From: Amanda Scholes on behalf of Planning.Responses
Sent: 18 June 2020 11:56
To: Planning Scanning
Subject: FW: FG/51/20/HH

From: [REDACTED]
Sent: 17 June 2020 15:39
To: Juan Baeza <Juan.Baeza@arun.gov.uk>
Subject: FG/51/20/HH

There are fundamental errors on the Roof Plan and the East and West Elevations. I would suggest these errors be rectified so as to validate the application.

Proposed North Elevation

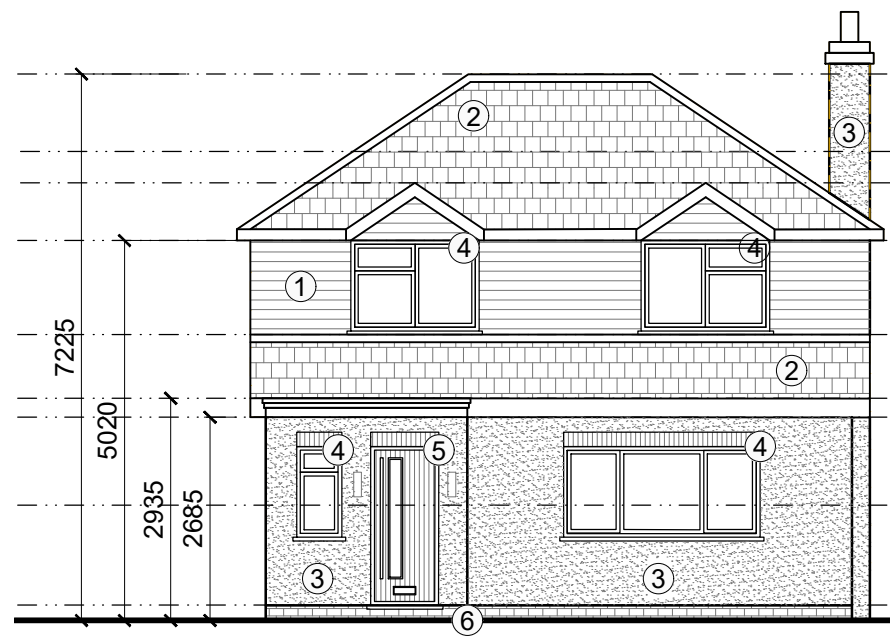
The front elevation (North) shows a 'full width dormer'. This is not in keeping with all the other extended bungalows in Elm Park, none of which have a full width dormer on any elevation.

Proposed South Elevation

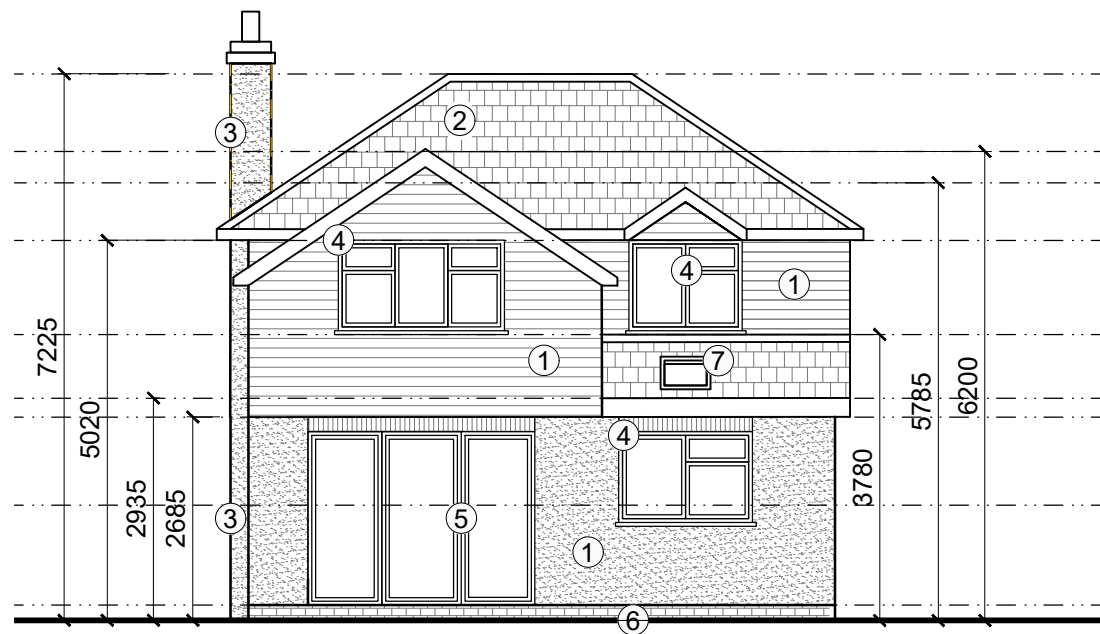
The proposals also show a two storey extension to the rear of the property (South). None of the extended properties in Elm Park have a two storey extension. They all have dormer type extensions.
